Our Ref: SSGS0101 Rev B

30 April 2019

SSDA Statement for Fire Engineering - Sikh Grammer School (Rouse Hill) (DRAFT)

Please find below our fire engineering statement to accompany the SSDA submission for the proposed development of the Sikhs grammar School Sydney (Rouse Hill Campus).

# CONSTRUCTION STAGE 07 - BASEMENT PARKING - SITE PLAN

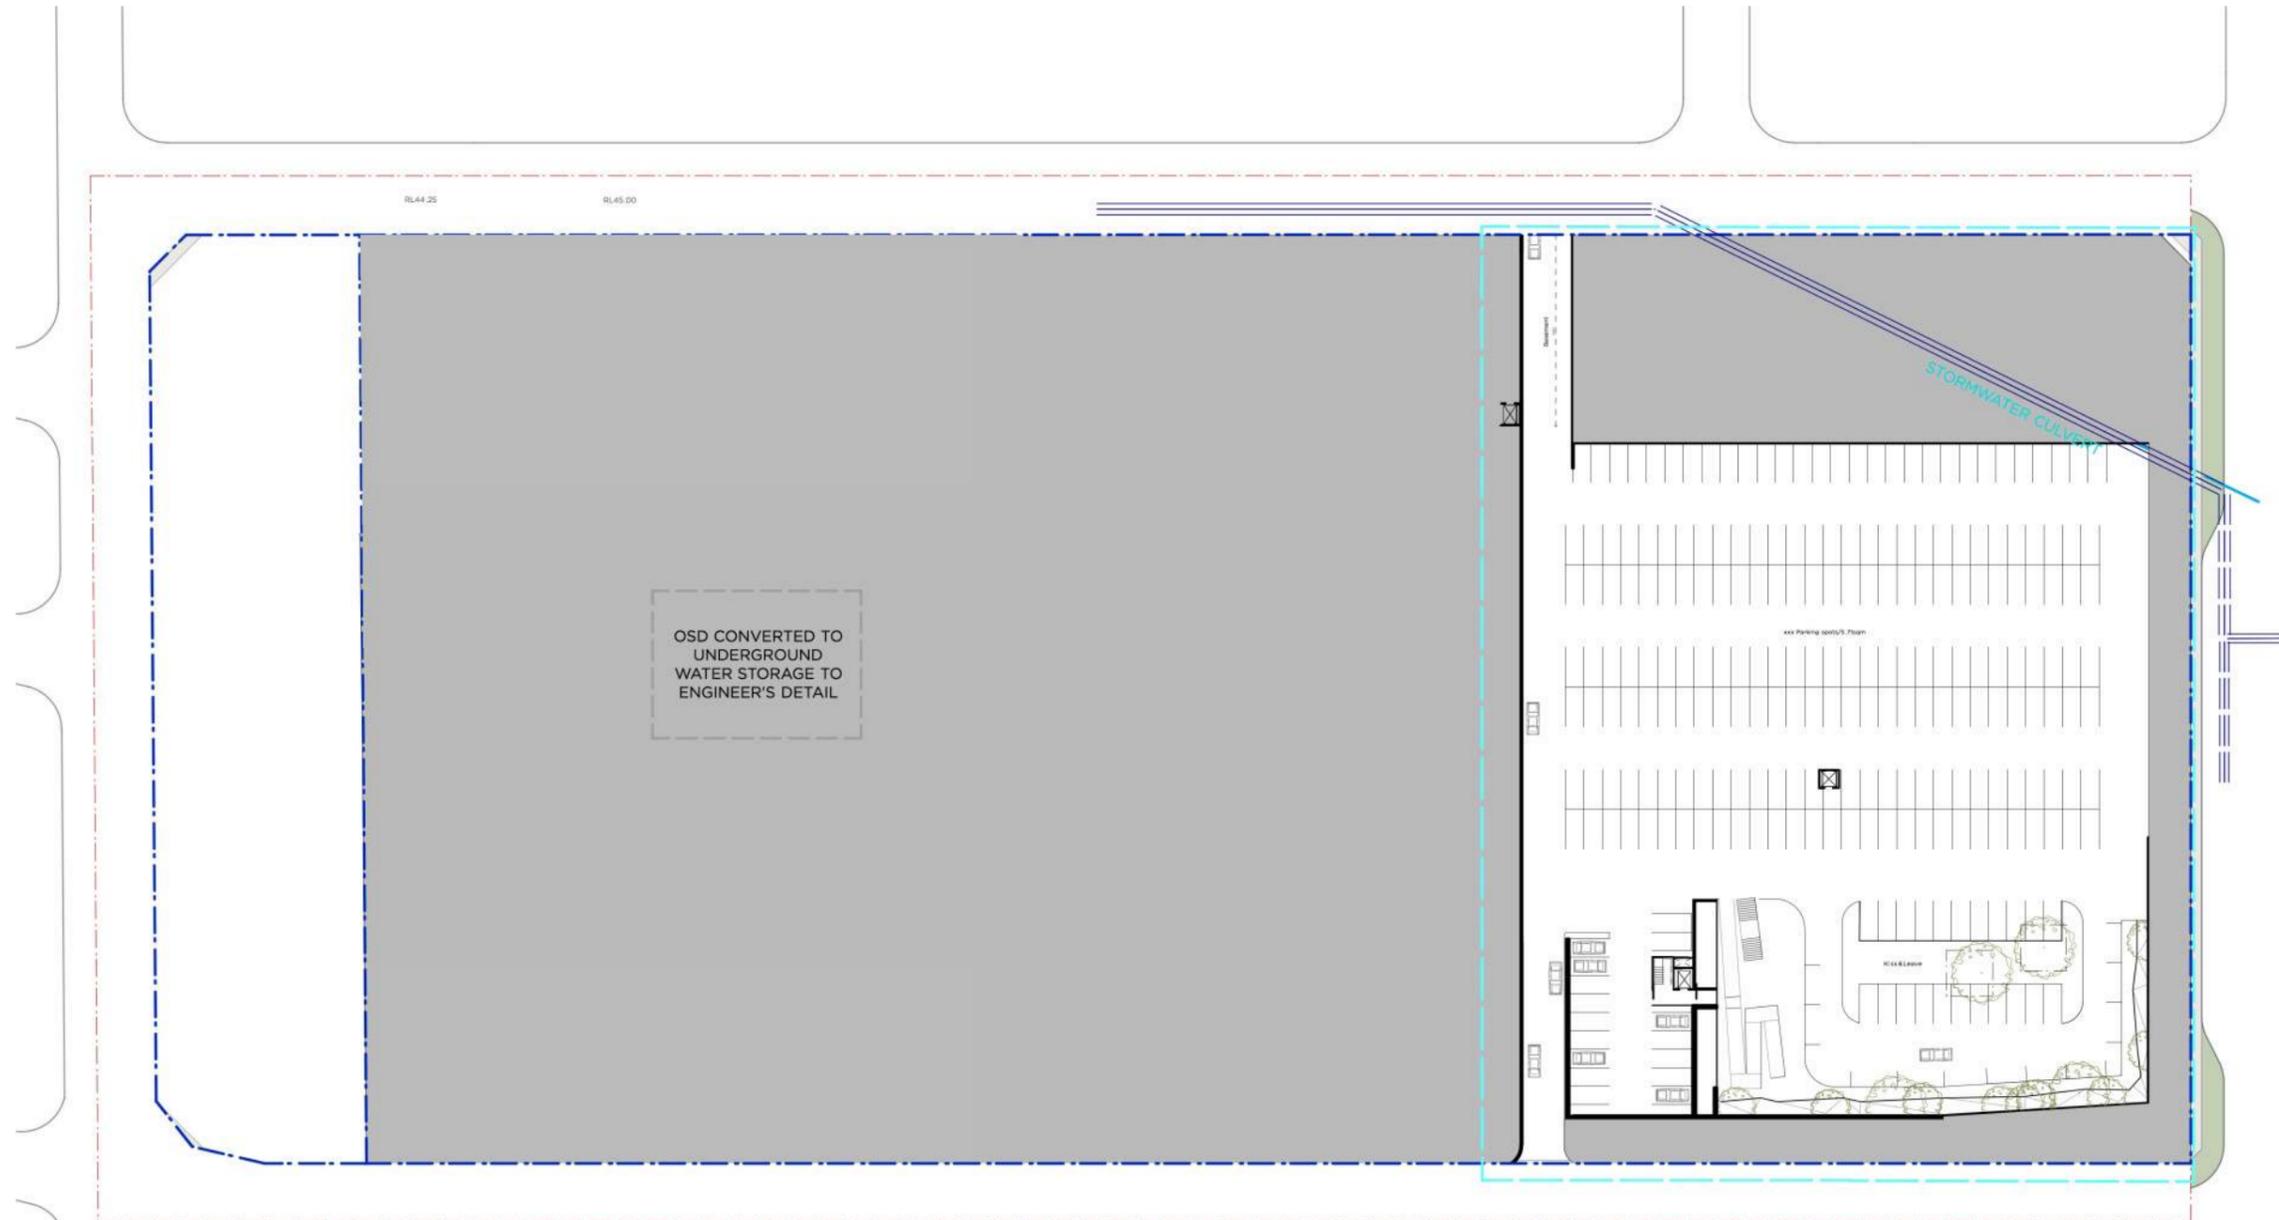
7.	C3.3, C3.4	Basement Carpark - The opening to the pedestrian ramp area servicing the Basement Carpark is positioned within 6 m of the Primary School complex which is a separate fire compartment. The openings to the carpark may be difficult/impossible to treat. The Fire Safety Engineer to review and confirm if a justifiable Performance Solution is feasible. Fire separation to the adjacent wall of the Primary School building may or may not need to be fire rated as part of this review.	Feasible to be addressed by Fire Engineering. Detailed assessment of the openings will be required during the detail design stage.
